From: Tim Townsend [REDACTED]
Sent: 01 October 2018 09:37
To: Planning.Responses
Cc: Michael Eastham; Derek Whittington
Subject: AL/20/18 - Proposed development of up-to 27 homes with access to the A29 - Land at Bridge Cottage and The Old Cottage, A29 Lidsey Road, Bognor Regis - WSCC Highways report dated 1st October 2018

TO:	Arun District Council FAO: Michael Eastham
FROM:	Highways, WSCC: Tim Townsend
DATE:	1 st October 2018
LOCATION:	Land at, Bridge Cottage & The Old Cottage, Lidsey Road, Bognor Regis, PO22 9PH
SUBJECT:	AL/20/18/OUT Outline application with all matters reserved for the demolition of 2 No. dwellings & associated outbuildings & the erection of up to 27 No. dwellings, of which 30% will be affordable, with associated open space & access. This application is a Departure from the Development Plan. <u>Further information.</u>
DATE OF SITE VISIT:	
RECOMMENDATION:	☐ Advice ☒ Objection ☐ Modification ☐ No Objection ☐ More Information ☐ Refusal
S106 CONTRIBUTION TOTAL:	£ See previous report.

This is the third WSCC highways and transport (CHA) response to the above outline planning application with all matters reserved for the demolition of 2 No. dwellings & associated out

Figure 4.1 – Illustrative Site Plan

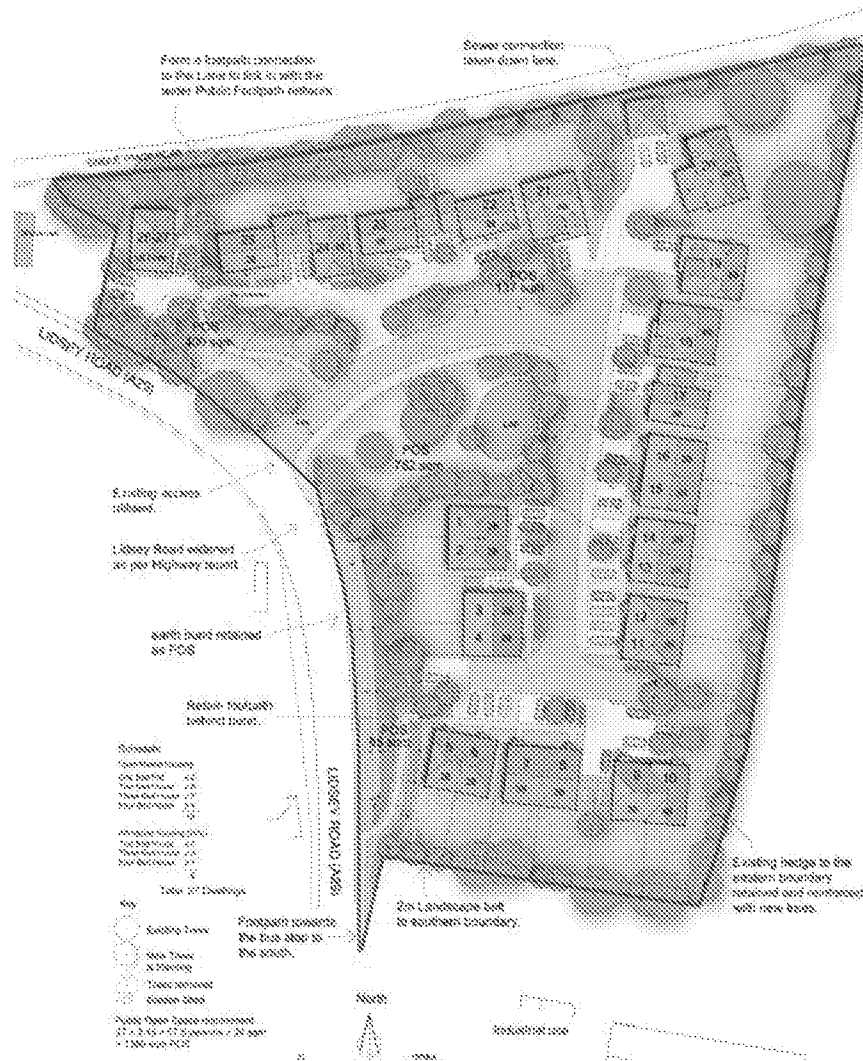
The internal layout is shown indicatively on drawing 1749-02G. As submitted, it is not clear whether it would be suitable for adoption under S38. This would be a matter to be looked-at at any Discharge of Condition (DOC) or Reserved Matters (REM) staged. Also, it is not known what form of surface water drainage is proposed for the site which might itself dictate whether the layout can or can't be adopted.

With regard to access by refuse and fire appliances, the access drive shown to plots 22-27 might need widening as in places it looks slightly restrictive (particularly adjacent to plots 25-27). As such, this would have to be considered further at any RES/DOC stage.

Project		
OLD COTTAGE LIDSEY		
New Access Design		
Drawn	Date	Scale (at A3)
TE	19/07/2018	1:500
Doc no.	Revision No.	
OCL/SR/701	C

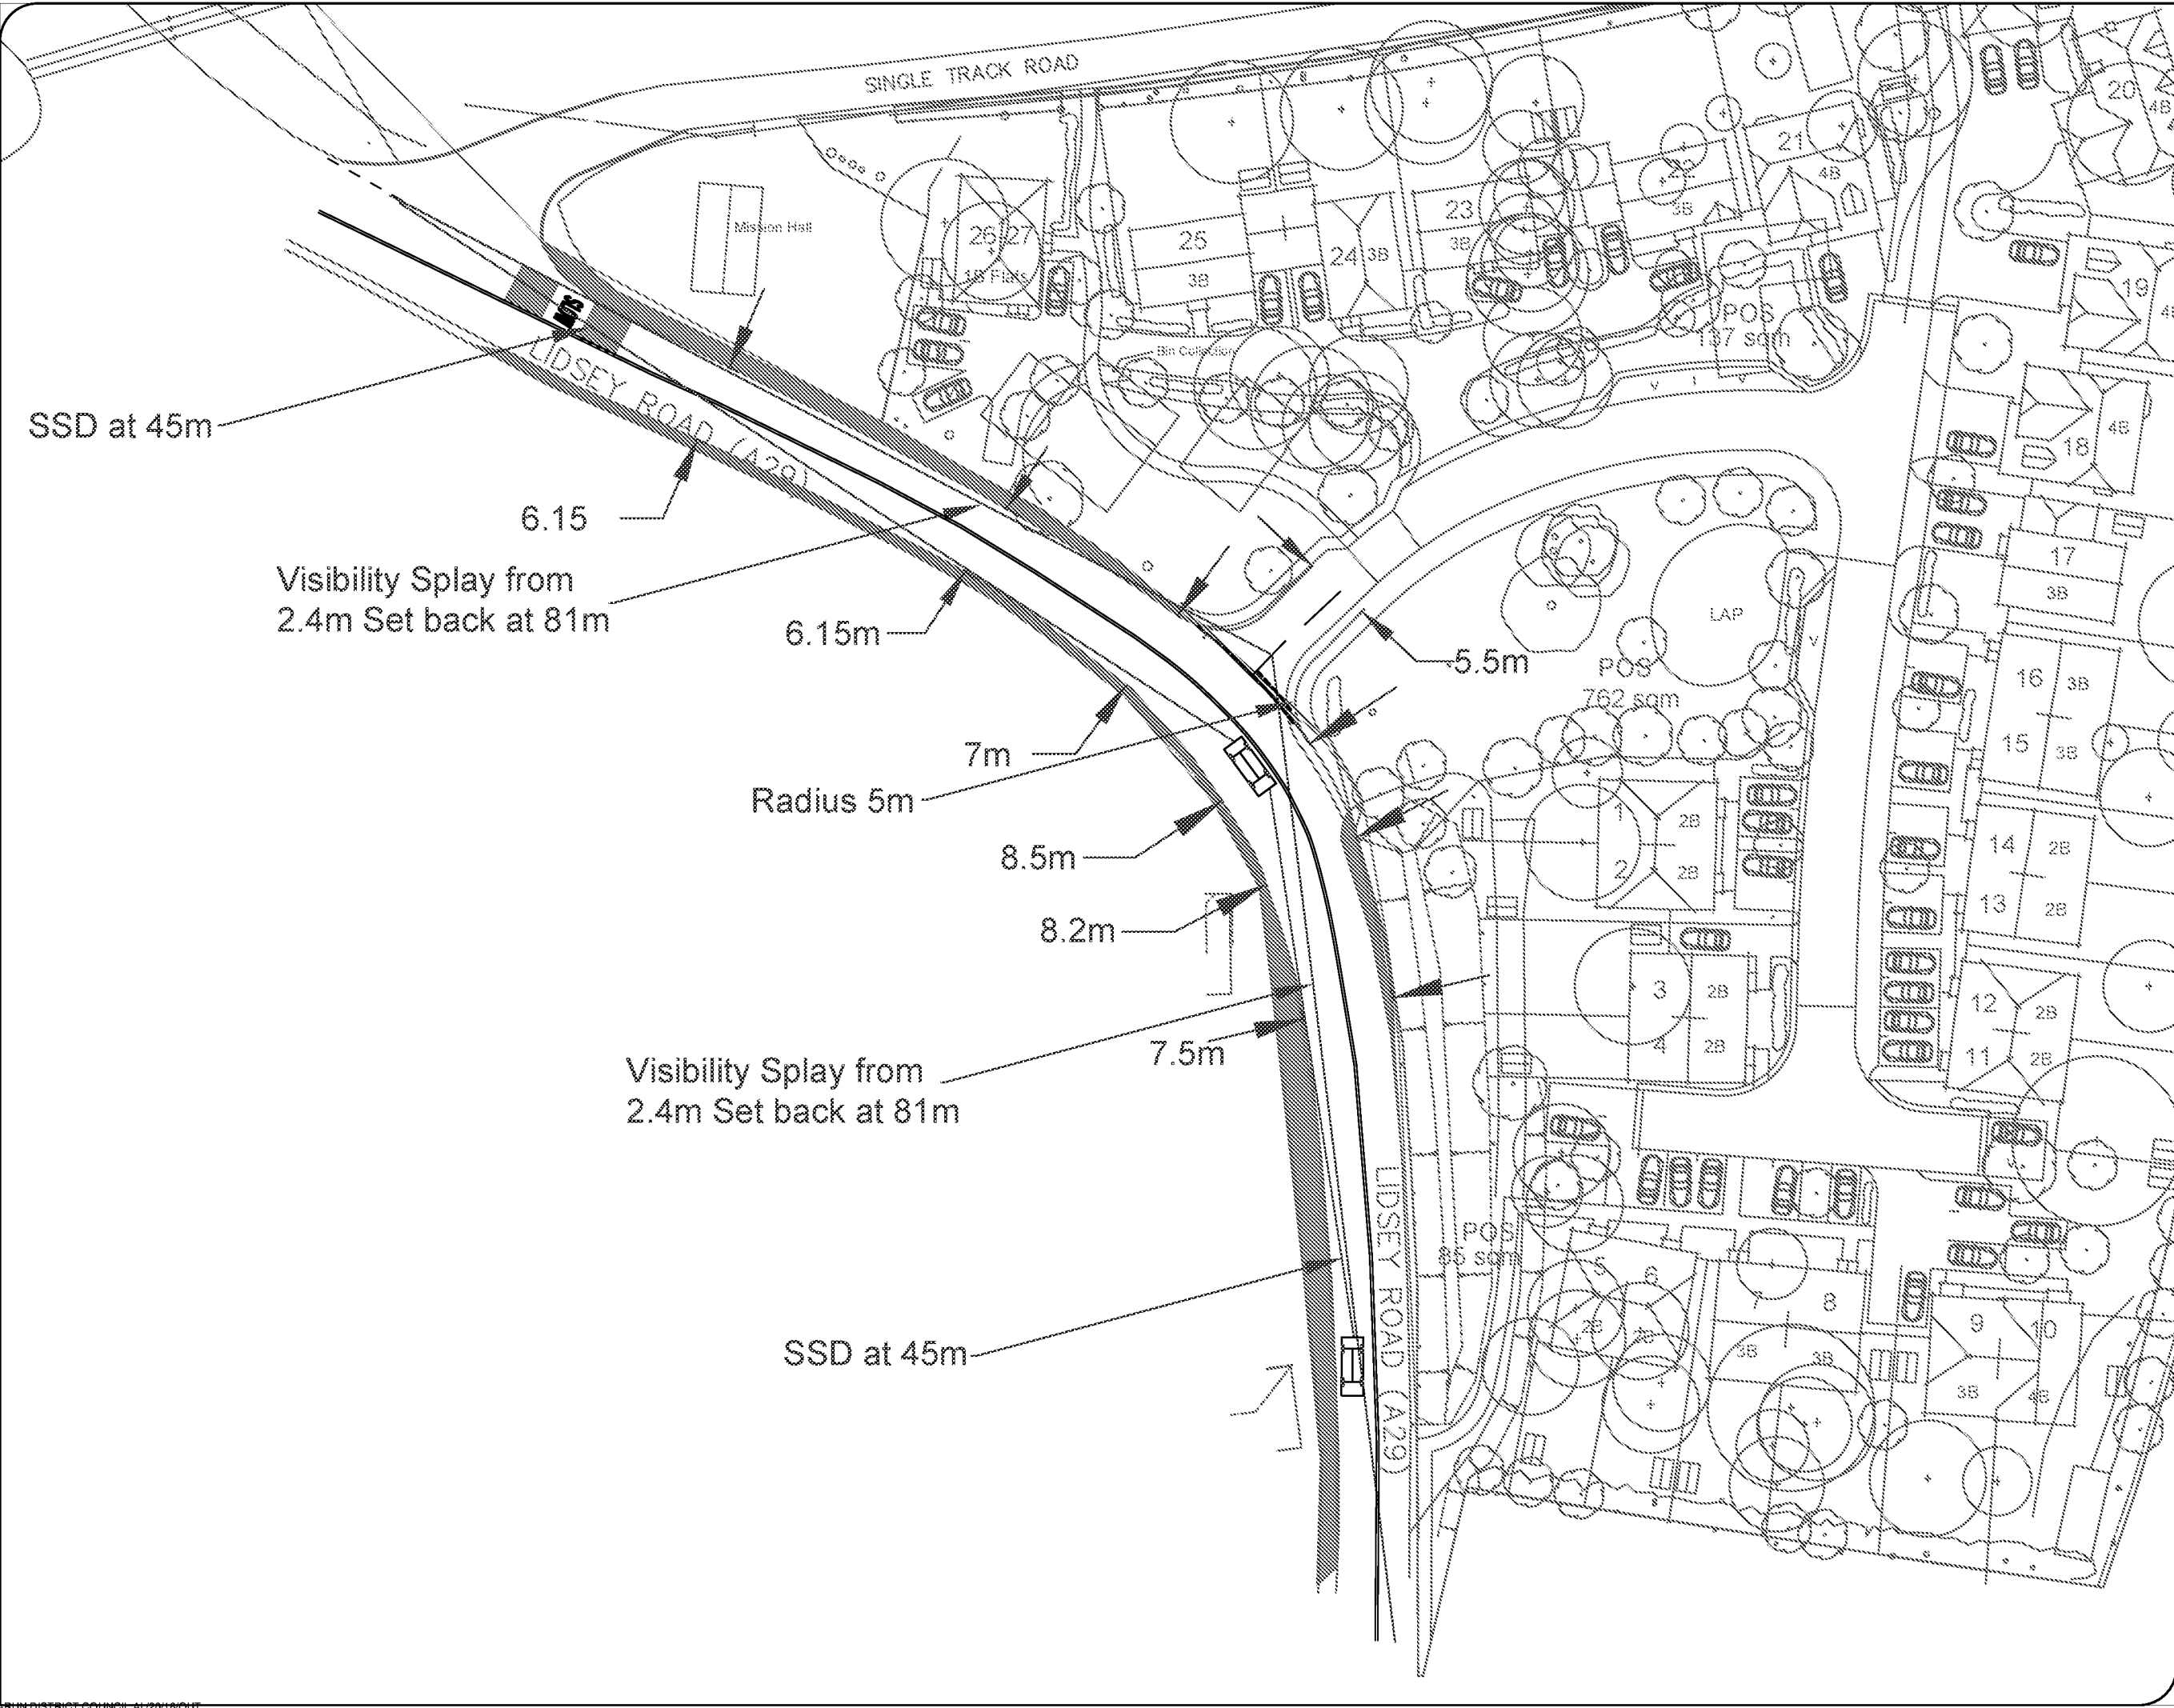
Vehicular access continues to be shown directly off the A29 on the apex of a bend in the road. The Applicant's Transport Consultant has confirmed that the proposed access road would measure 4.8m wide with 5.0m bellmouth radii.

In previous correspondence, the CHA recommended that the bellmouth radii be increased to 9m to assist with passage of vehicles (particularly service vehicles) in-and-out of the access given that it connected to the busy A29. In the Transport Consultant's reply, he states this is unnecessary given that the larger the radius, the higher the traffic speed. However, the CHA

recommended it in order to safeguard users of the junction and those already on the A29 when traversing through it. If the radii are found to be too small, this can lead to vehicles over-sailing the centreline of both the new access and/or the main road (in this case the A29) into the paths of oncoming vehicles. This could have road safety implications. On this occasion, as the application is fully outline with all matters are reserved, the CHA considers that it would be reasonable for the applicant to produce swept-path diagrams to 'track' the movement of vehicles through the junction at this later stage if outline consent is granted. That then can inform the final dimensions of the junction layout. Also, the matter can be brought to the attention of any Audit Team undertaking any subsequent Road Safety Audit.

Visibility splays are taken from a 2.4m 'x' distance with major road 'y' distances of 81m in both directions as shown on 'New Access Design' drawing OCL/SR/701 Rev D. Forward visibility stopping sight distance (SSD) (i.e. that required for drivers of vehicles turning right and left into the site and corresponding visibility for drivers already on Lidsey Road coming-across them – from both north and south) was previously shown measuring 45m. Drawing OCL/SR/701 Rev. 'D' now states that the SSD measures 81m. However, this is not the case, driver-to-driver intervisibility (so that between someone waiting to turn left into the site and someone travelling southbounds along the A29 coming-across the turning vehicle), now measures 68m based on the location of the turning/waiting car as shown. If the location of the latter is moved slightly further forward, this would increase that dimension.

For the SSD for northbound vehicles, 67m is available based on the location of the waiting/turning vehicle as shown on the consultants drawing.

The CHA continues to recommend that the first 15m of the access road be constructed as a flat plateau in order to minimise 'rolling-forward' of vehicles towards the A29 when waiting to emerge to it. Alongside this, the A29 itself where it meets the access would need to be carefully designed to minimise chance of grounding of vehicles when entering or leaving the development site. Additionally, comments about surface water drainage are made elsewhere in this report and separately by the County Council's Surface Water Engineer.
